**Re: Revised Traffic and Parking Assessment
3 Clyde Street, Batemans Bay**

CLYDE RIVER MOTOR INN

Ground Floor Plan scale 1:200

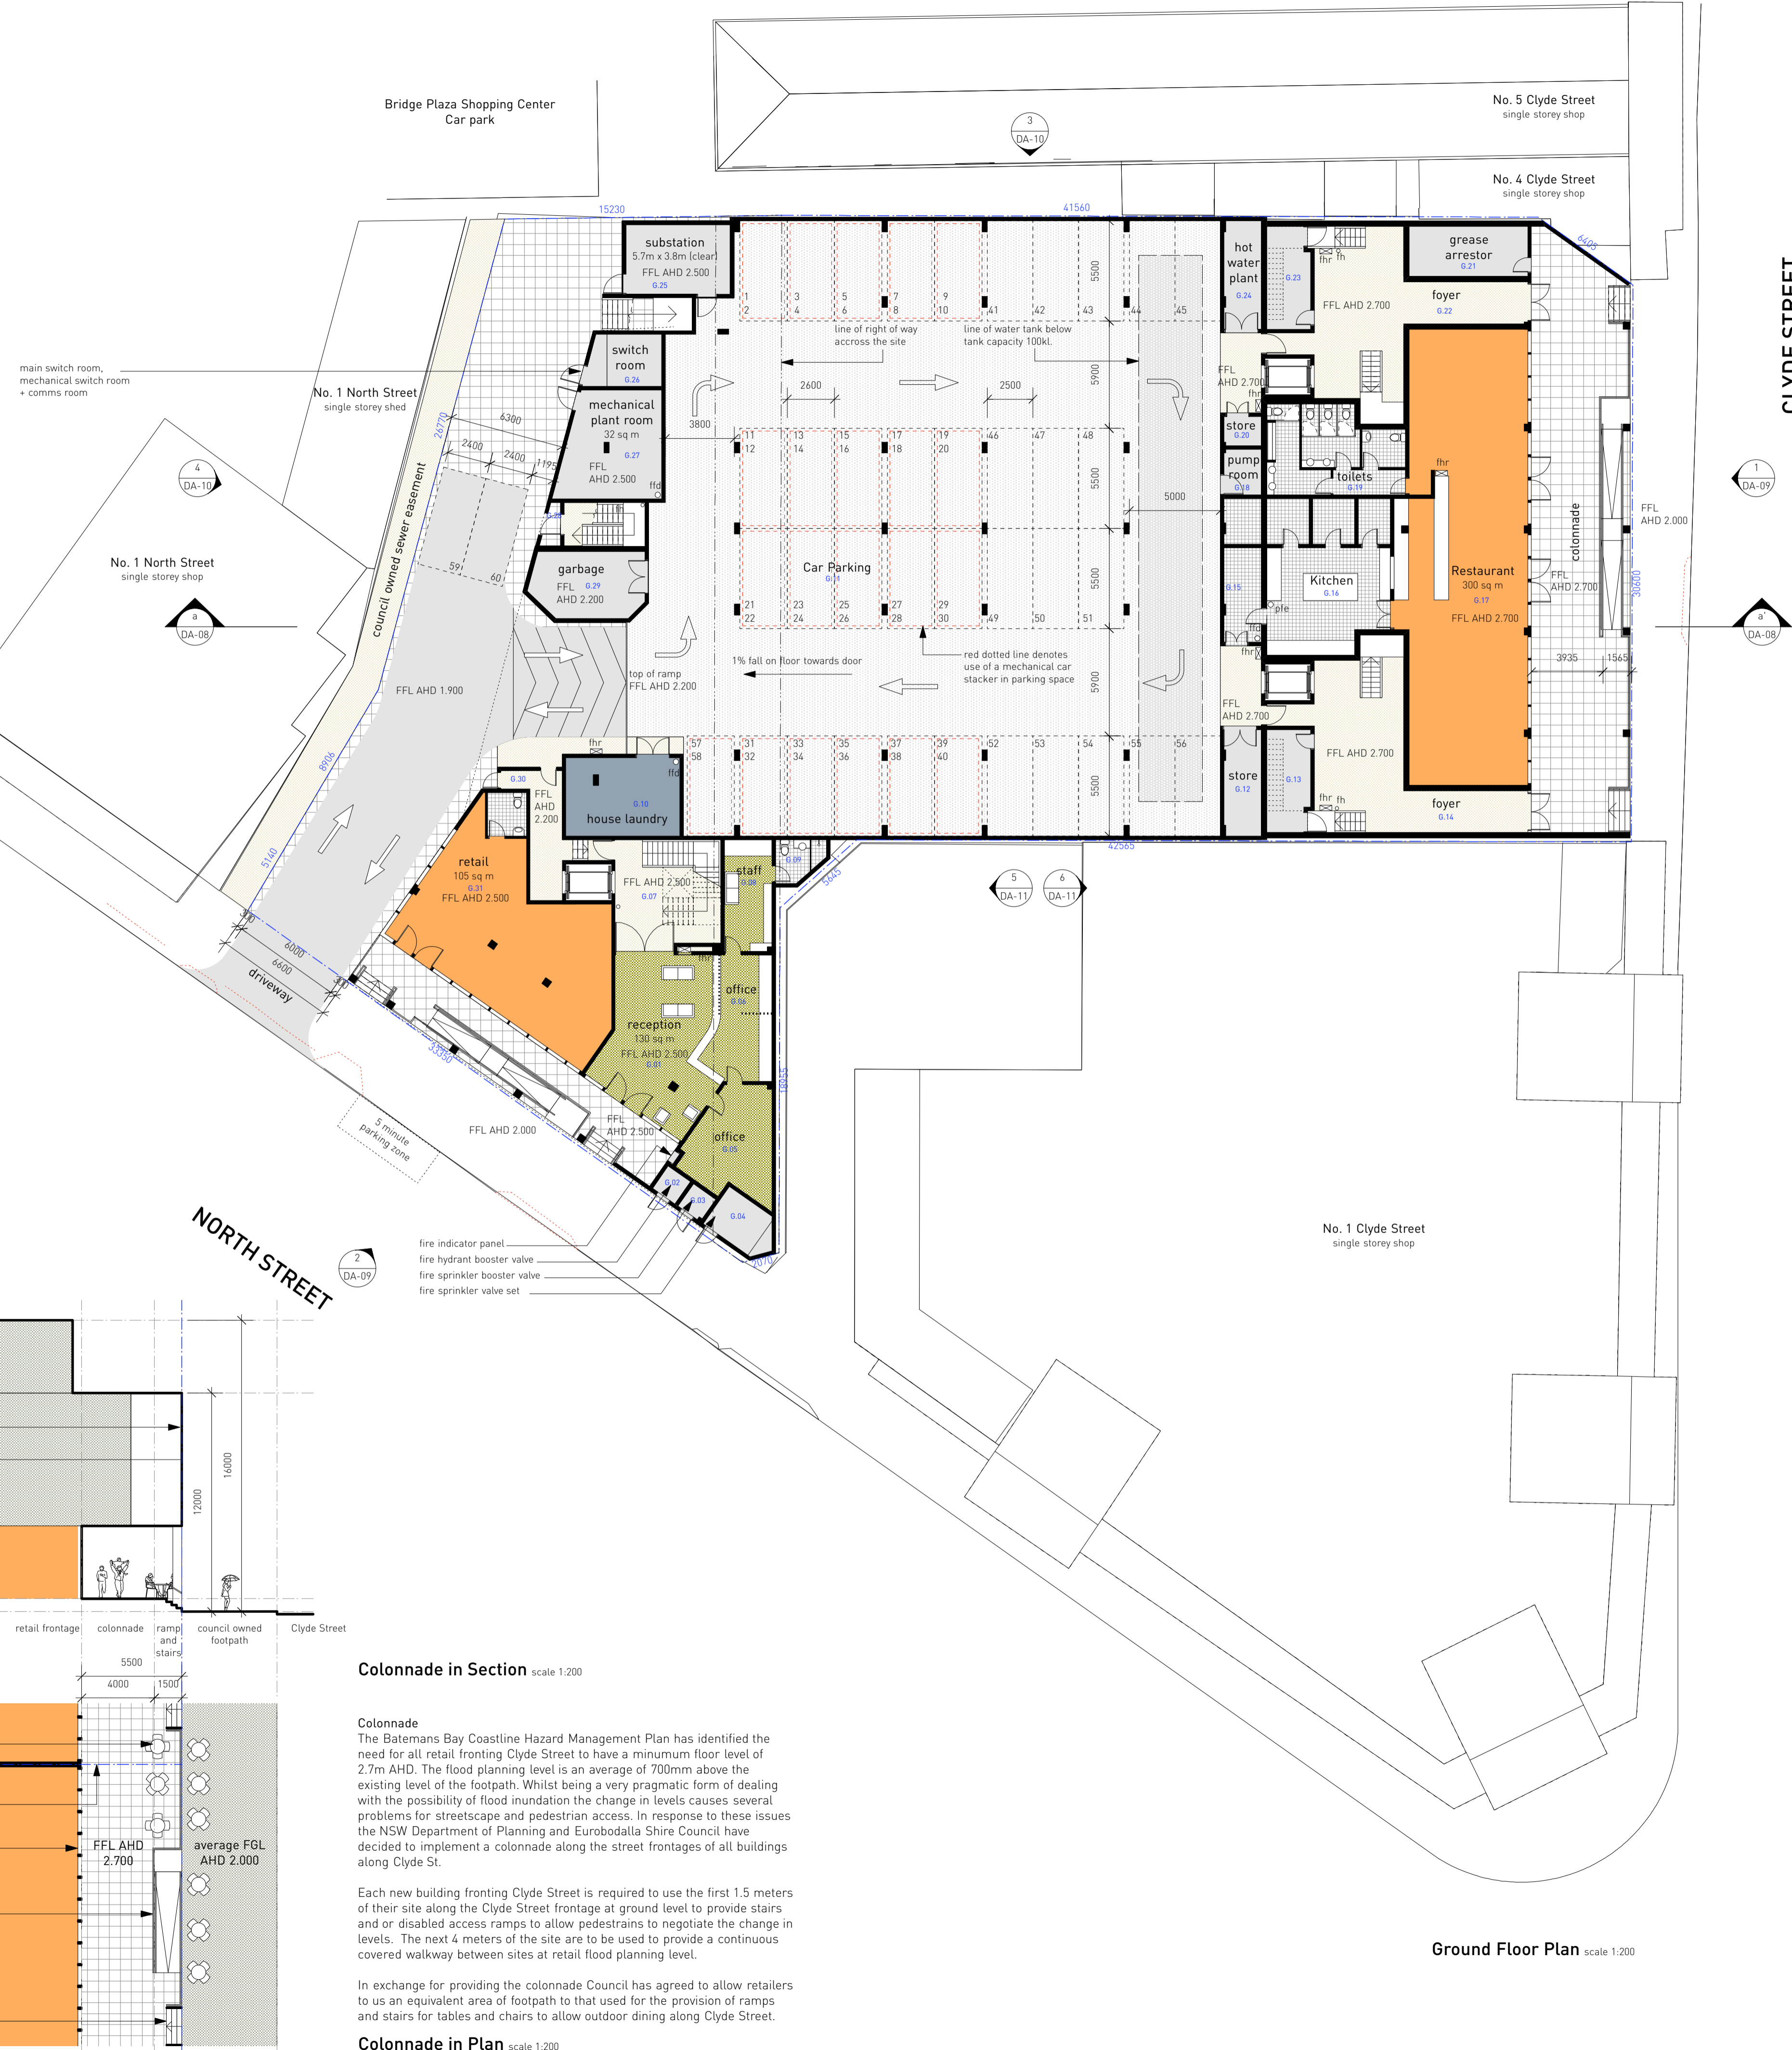
"Please clarify the 'required aisle width' for the car stacker of 6.95m, versus the effective aisle widths of 5.9m and 6m."

“From Figures 2 and 4, it appears that simultaneous entry and exit on the driveway will be tight. Please clarify this especially given that the valet system will be used for the serviced apartments only.”

"Para 2: Figures 2 - 4 appear to indicate an obstruction (adjacent to spaces 11/12, 21/22). Please clarify adequacy of swept paths."

The available aisle width between car stacker trays on either side of each aisle was measured to be 6.50m. This is also shown in **Figure 1**. Assuming the at-grade space is 5.4m long, the effective aisle width of at-grade spaces would be 6.10m.

The Australian Standard suggests that an 85th and 99th percentile vehicle should be able to pass where aisles intersect, on curved sections of ramp or where vehicle turning is required. We have tested an 85th and 99th percentile vehicle passing each other at the car park entrance. These turning paths are shown in **Figure 3** attached. From **Figure 3** it can be seen that there is adequate width for these two vehicles to pass concurrently. Therefore the proposed car park entry width and approach driveway complies with the Australian Standard and is considered satisfactory.

As stated above, the swept path of a 6.4m Small Rigid Truck has been prepared and overlayed onto the revised car park design. The manoeuvring space within the car park can accommodate this vehicle type which is expected to be the largest vehicle which would access the car park. The proposed layout of the car park is accordingly considered satisfactory.
